RMS responses to comments raised by DP&I's independent bridge condition review

**B 415 Windsor Bridge
Follow-up Inspection
15.6.2011**

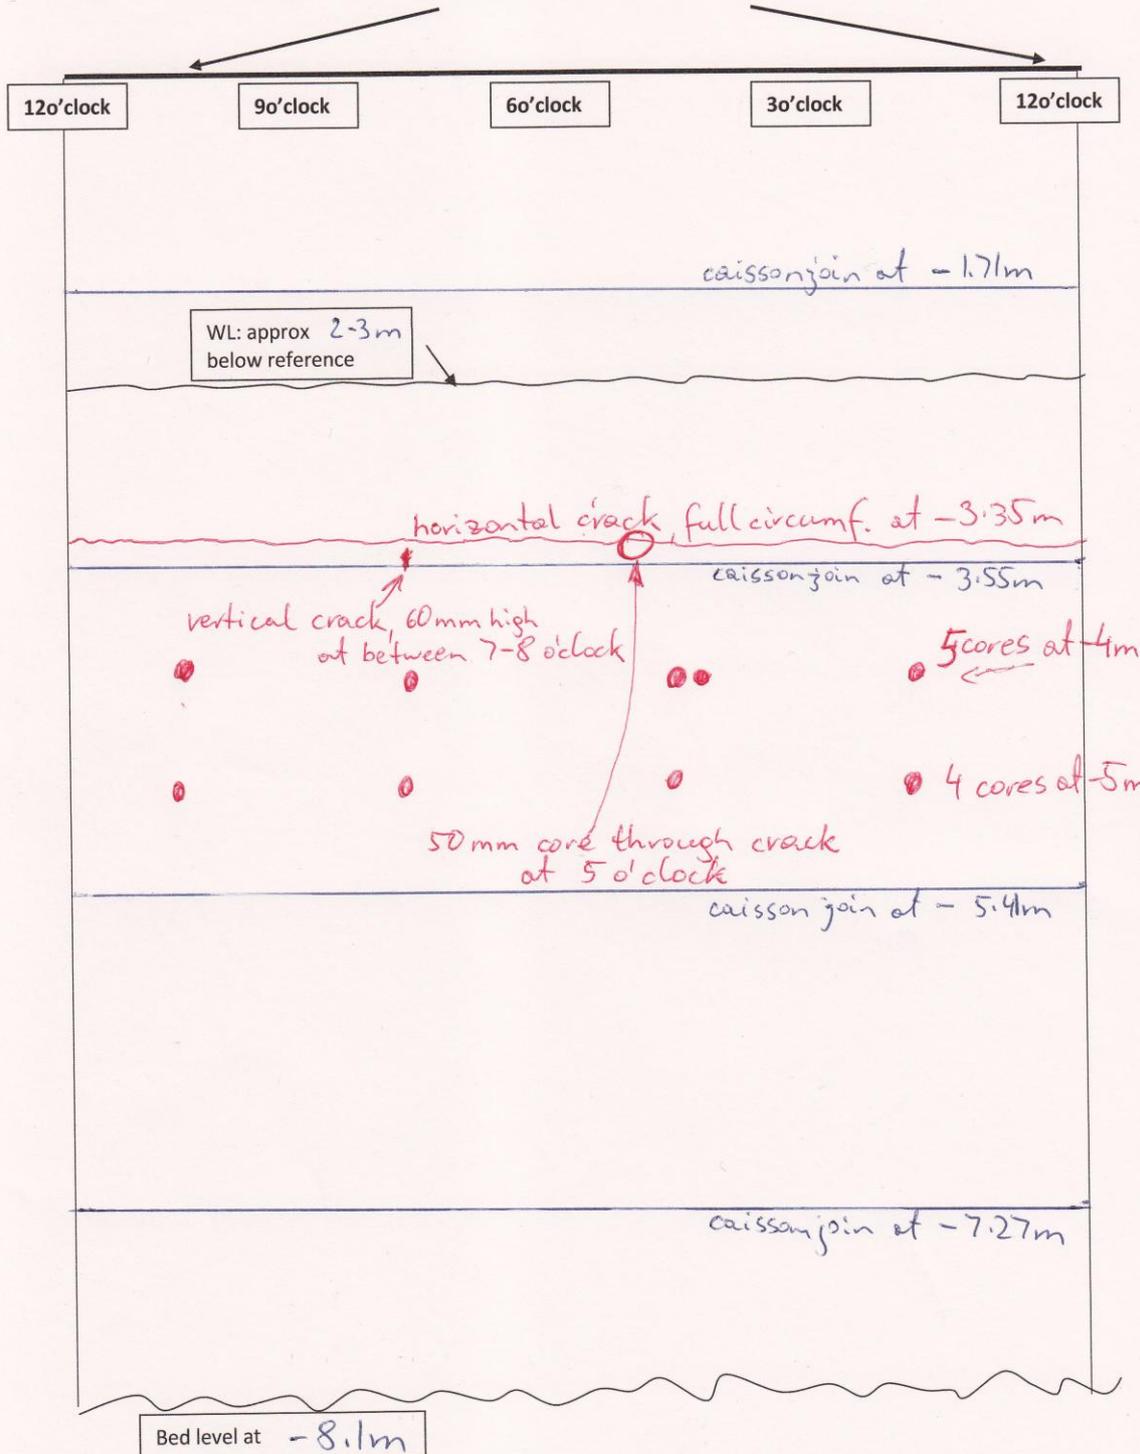
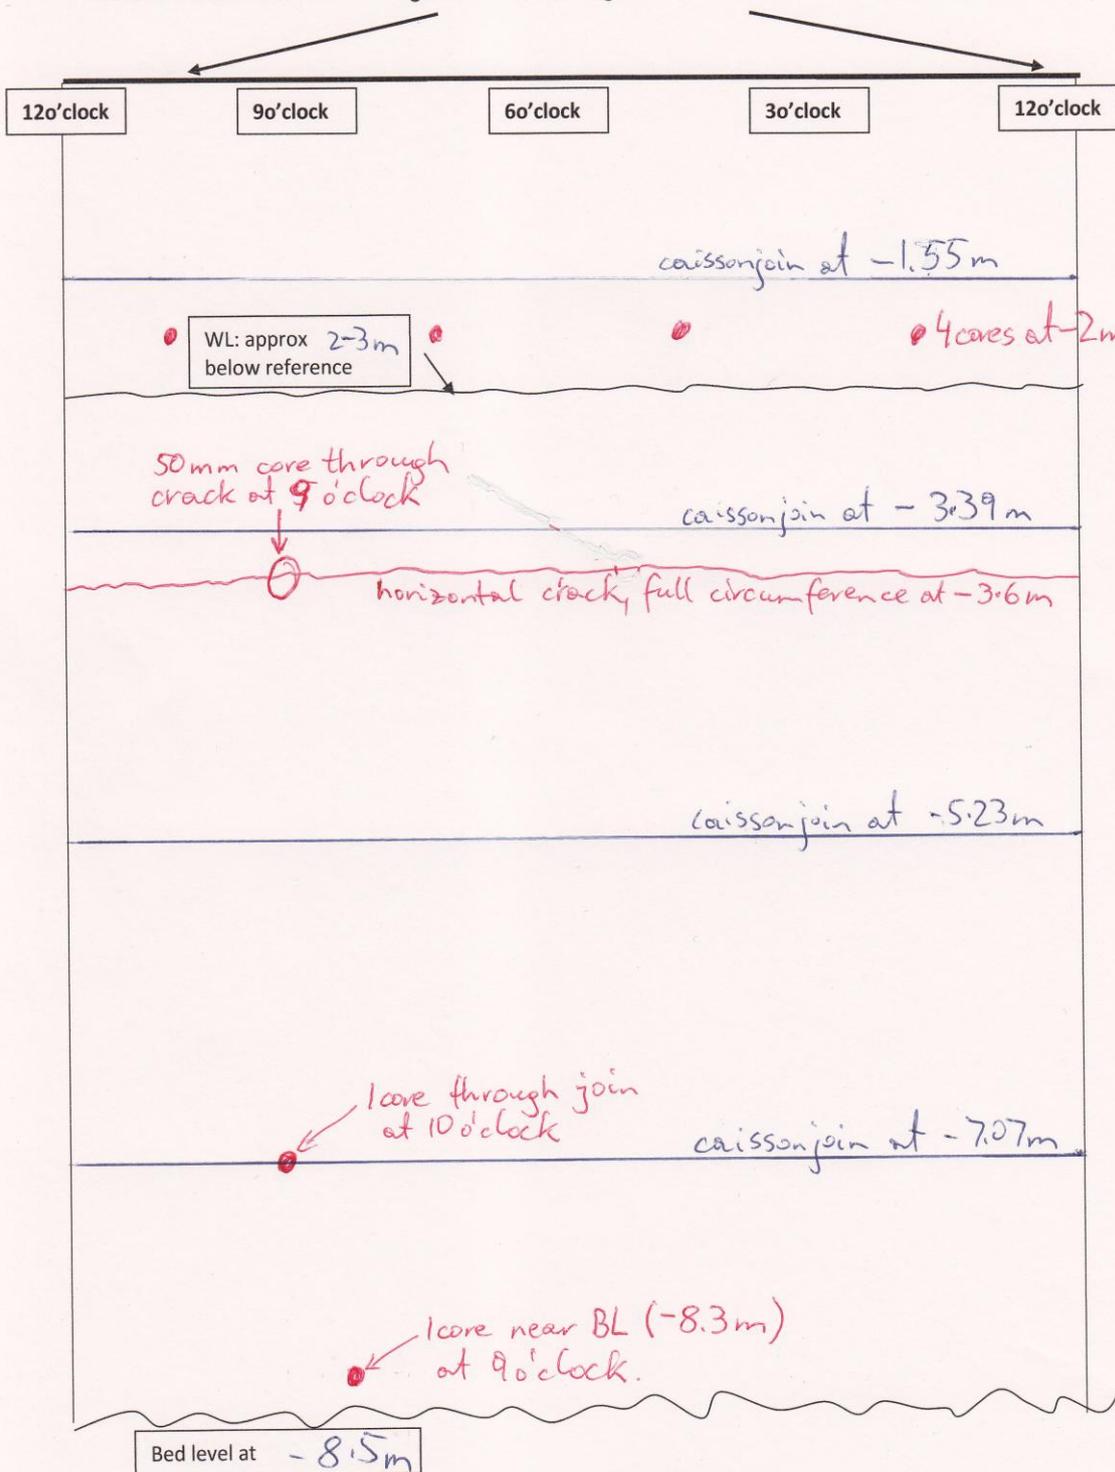
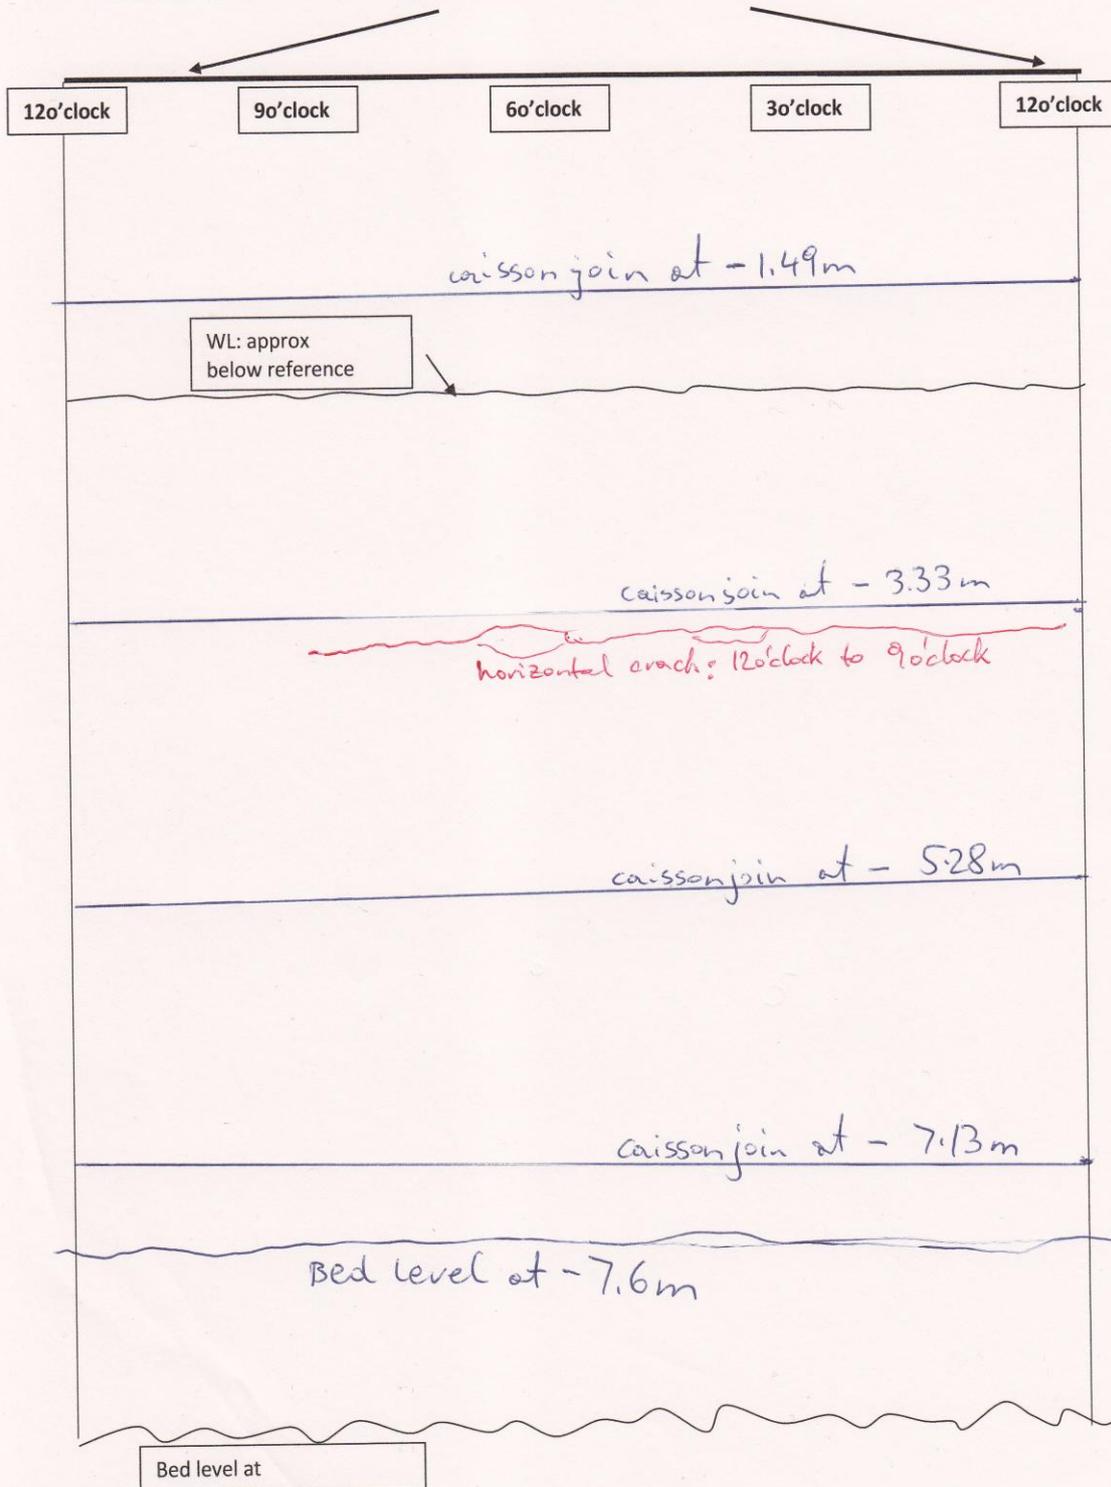
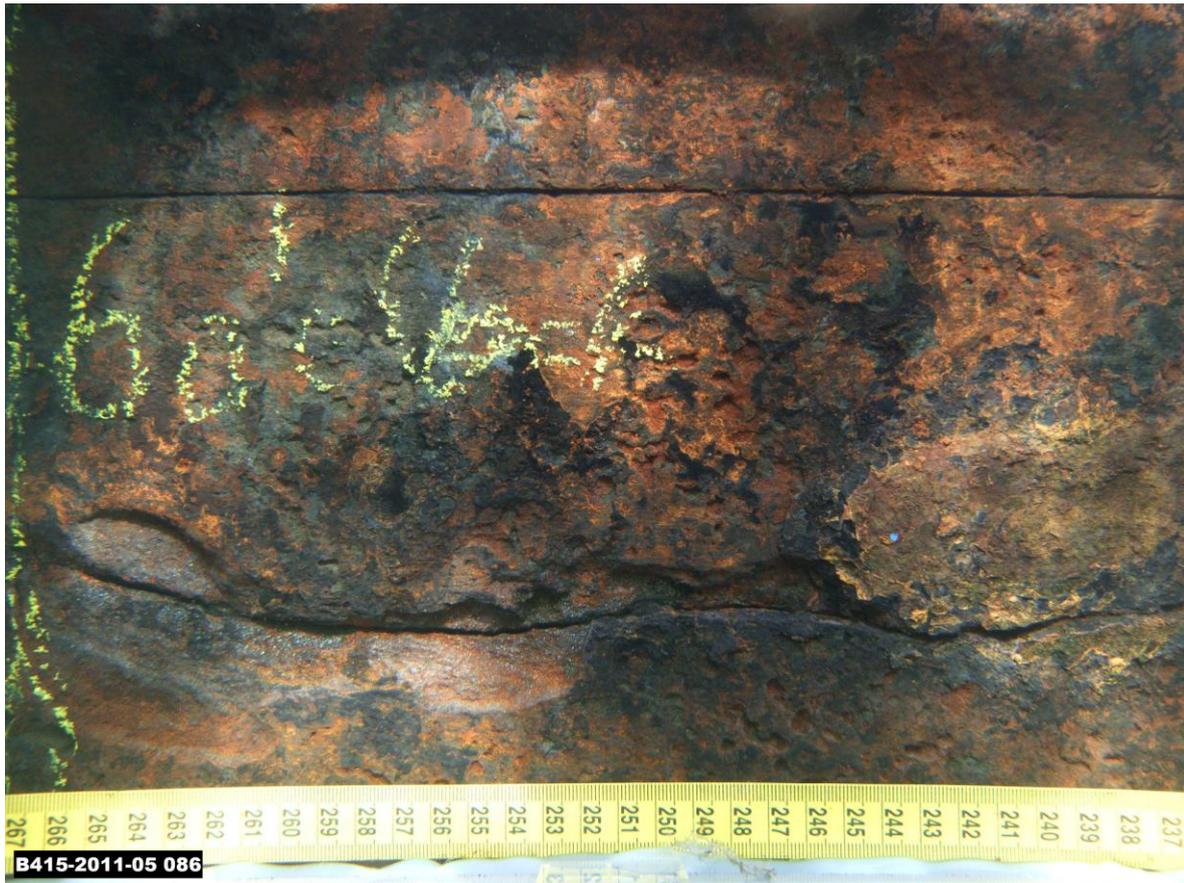
18. Please confirm that graphitisation was first identified in 2005 by CTI Please confirm cracks in some cast iron piers were first identified in 2011 by CDS	Confirmed
